Application for a non-material amendment following a grant of planning permission.

Number	1
Suffix	
Property name	
Address line 1	Finch Gardens
Address line 2	
Address line 3	
Town/city	Bersted
Postcode	PO22 9EQ
Description of site location must be completed if postcode is not known:	
Easting (x)	492987
Northing (y)	101096
Description

Erection of 1no. attached dwelling	
Reference number:	BE/74/18/PL
Date of decision	10/07/2019

Drawing Title
Proposed Plans - NMA

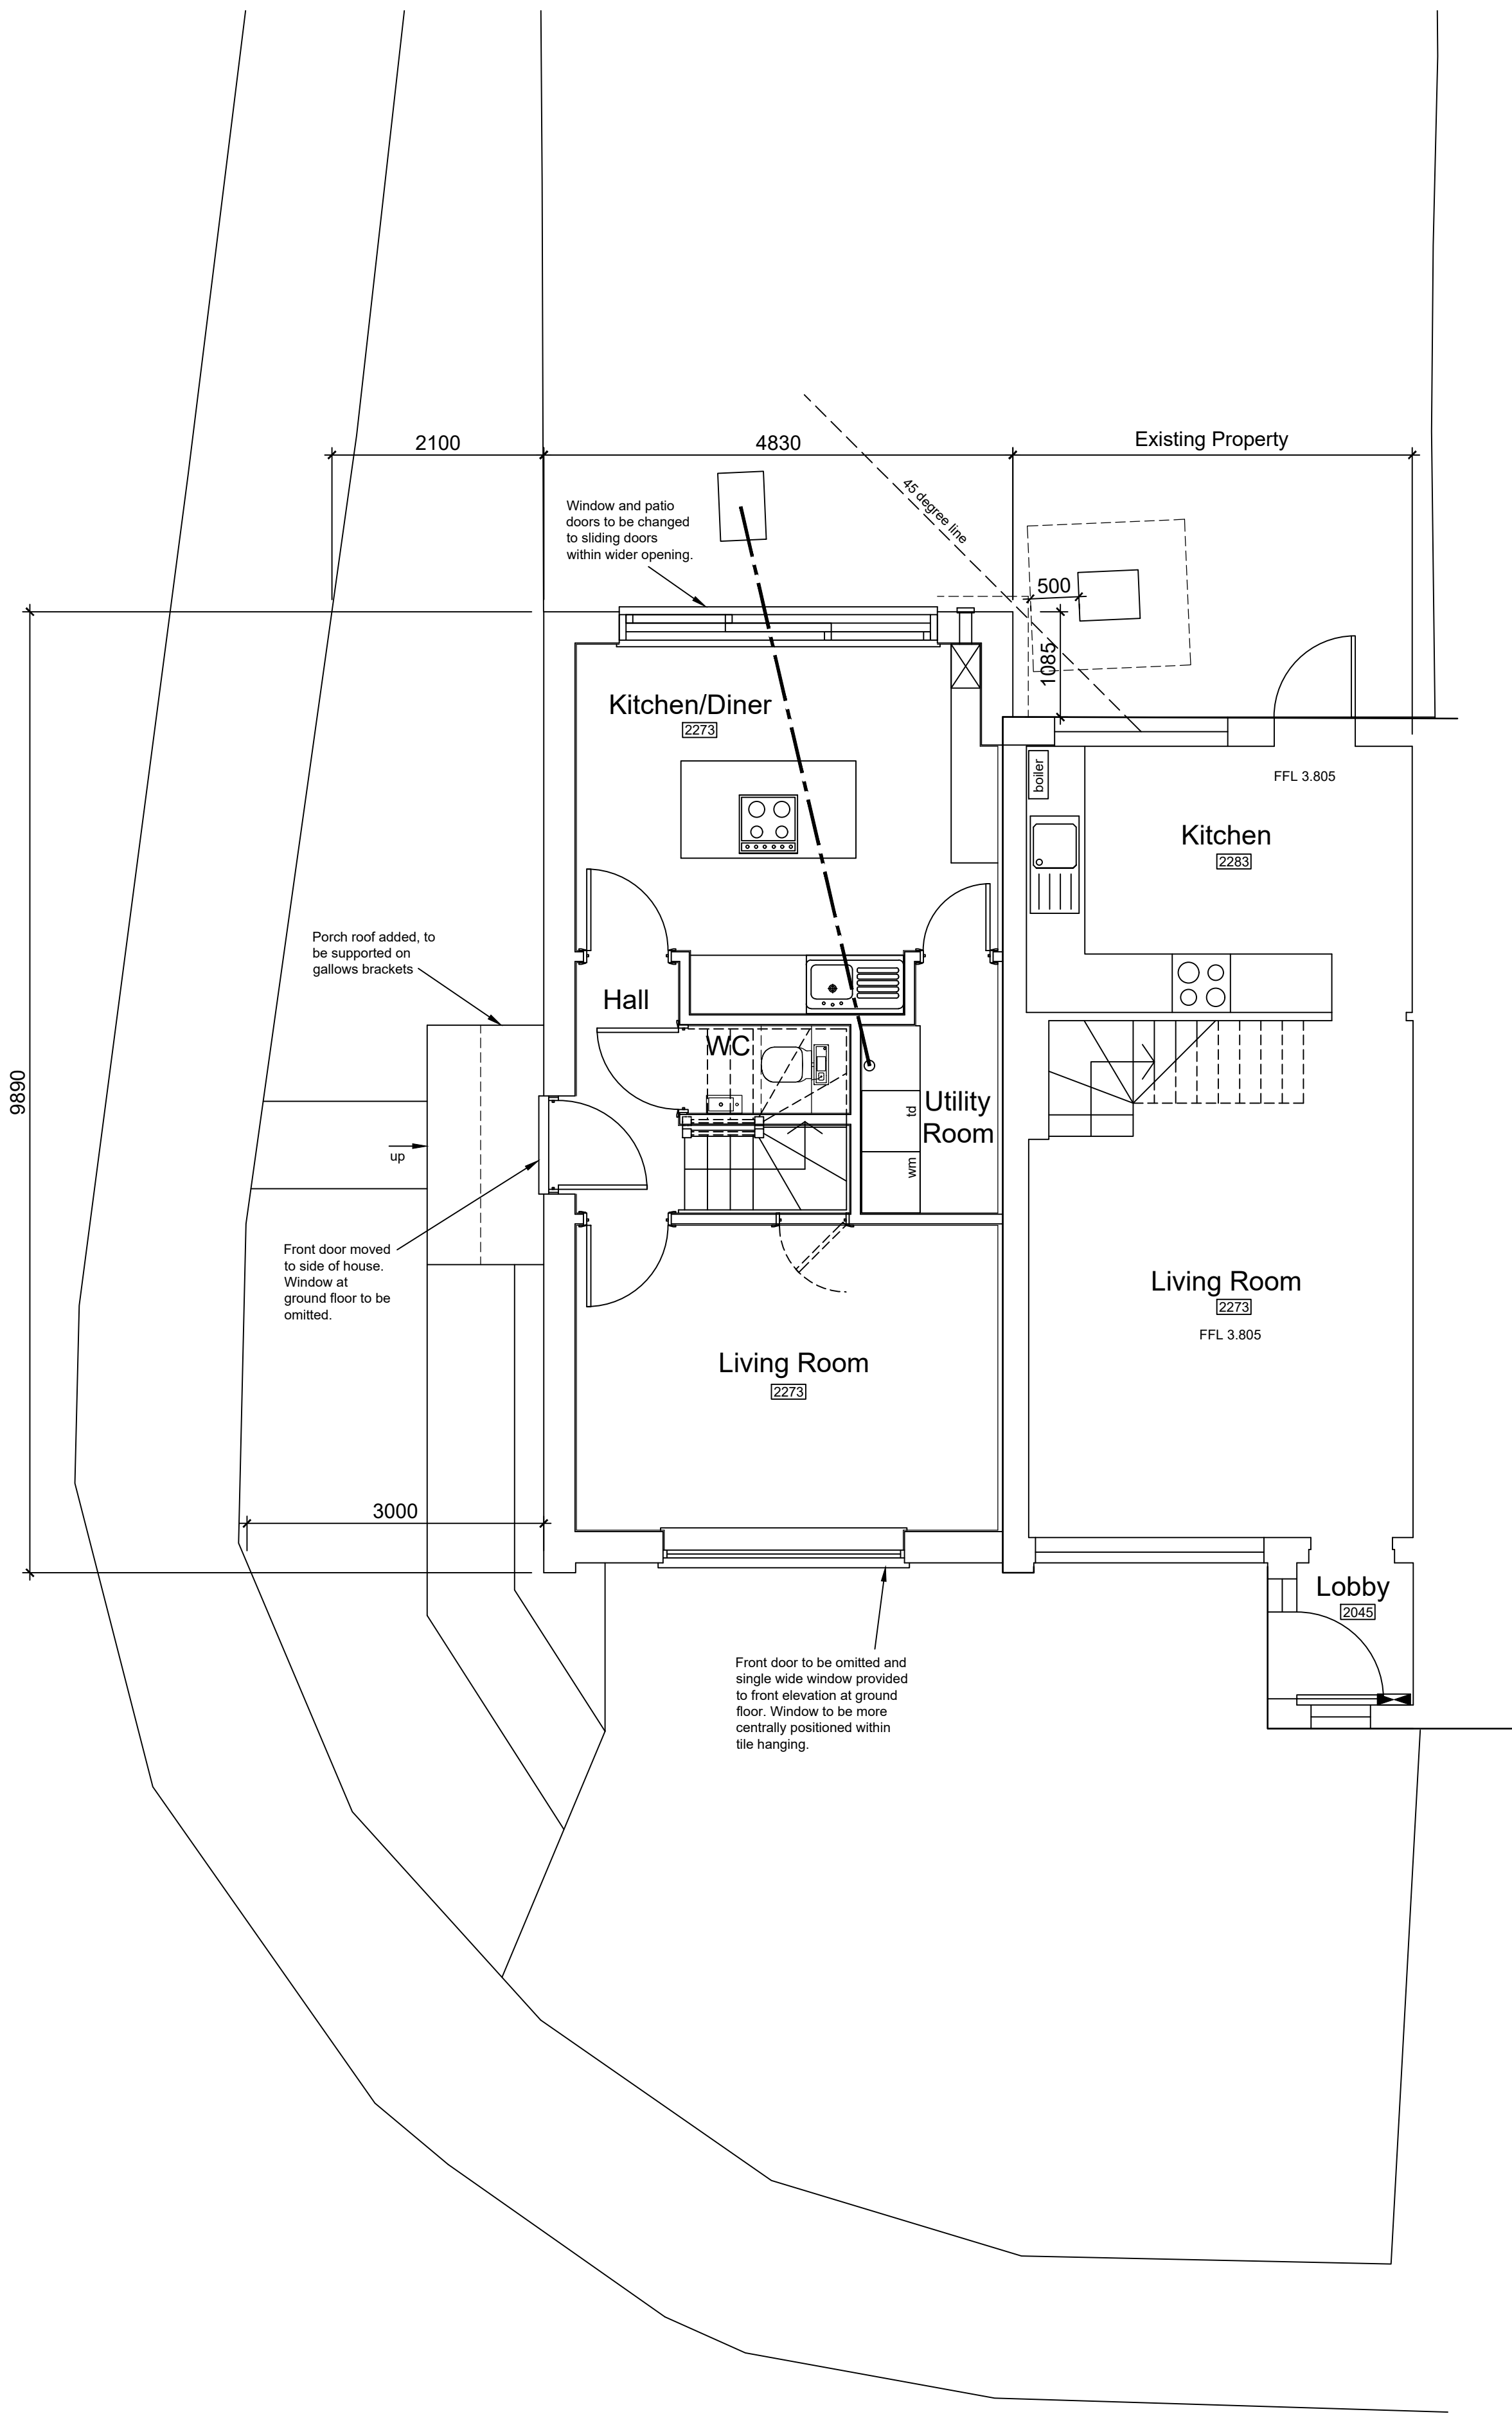
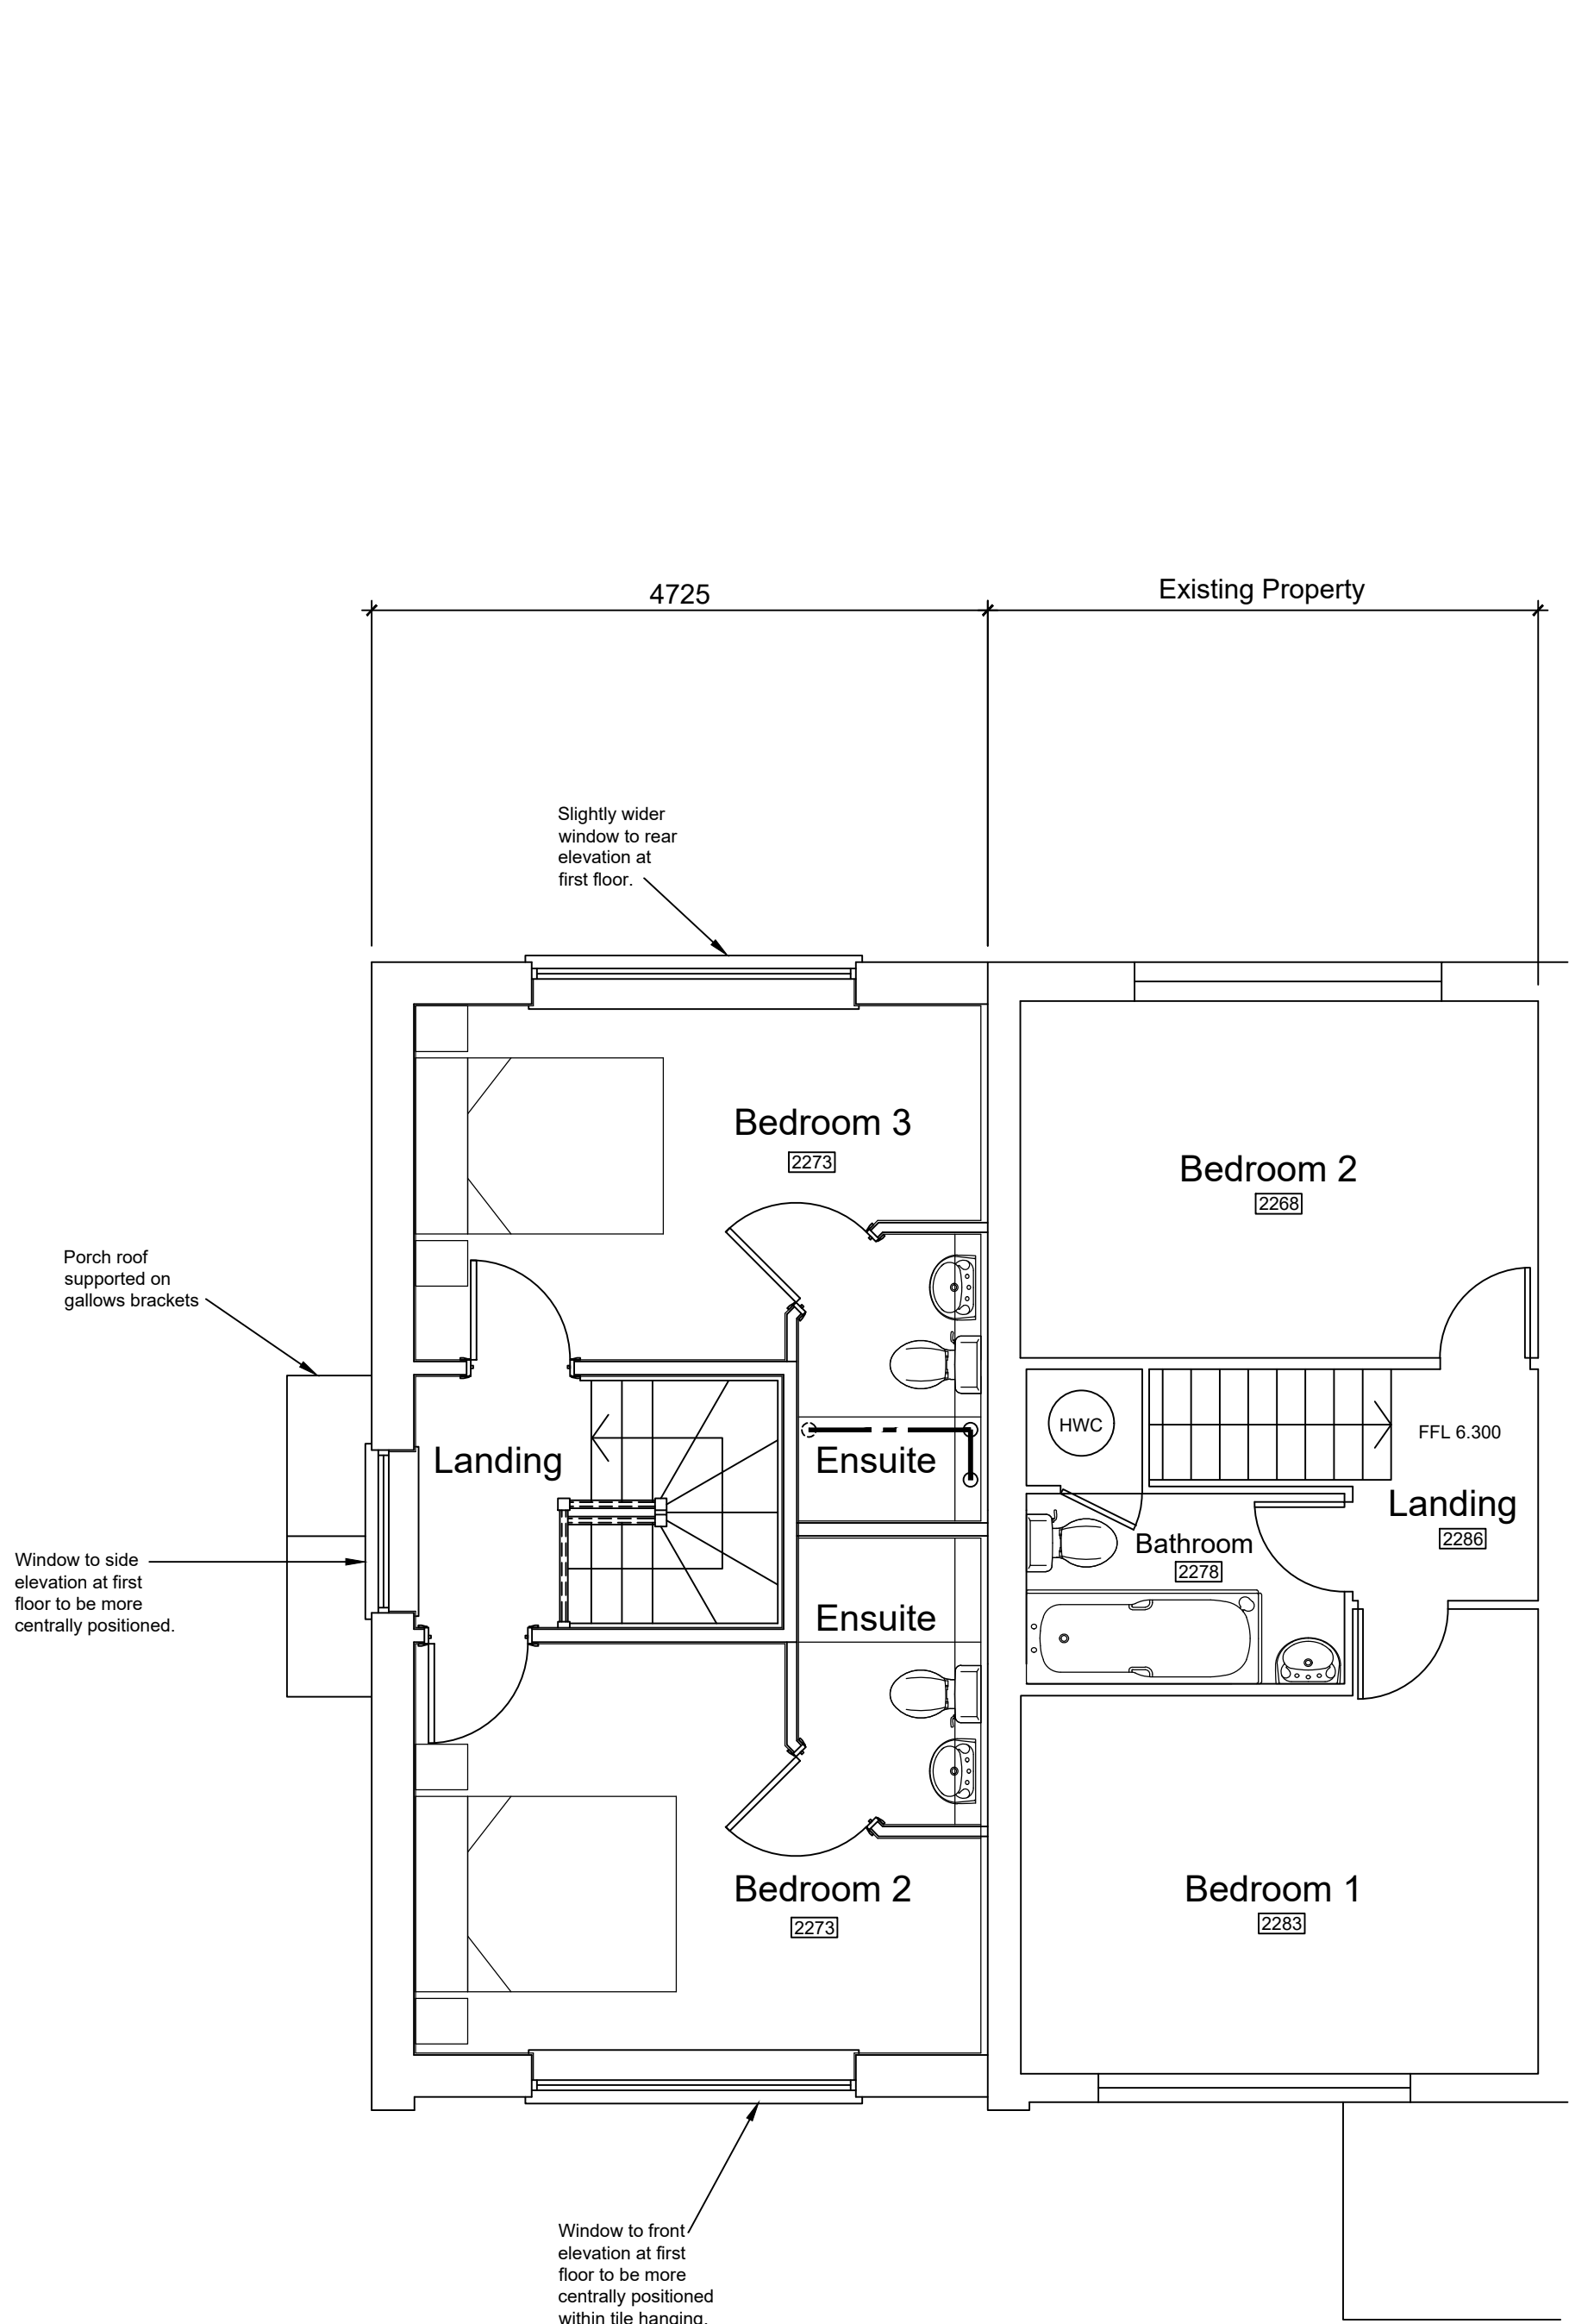
Front door moved to side of house and new porch roof canopy supported on gallows brackets and new path provided.
Windows on front elevation decreased slightly in width and centred.
First floor window on side elevation centred.
First floor window on rear elevation to be made slightly wider.
Ground floor door and window on rear elevation to be replaced with sliding doors within a wider opening.
Short side wall to rear projection to be moved away from existing house by approx. 20mm, so that its foundation can be 500mm clear of public sewer manhole.
The ground floor rear wall has been moved out by 25mm, so that the long side wall of the house works to brick dimensions.
Internal layout altered.

The staircase on the approved plans did not meet building regulations and a reorganisation of the internal layout was required to achieve a building regulations compliant staircase. The client also wished to improve the internal layout to provide a front entrance into a hallway, as well as a utility room, whilst making better use of the space adjacent to and under the stairs.
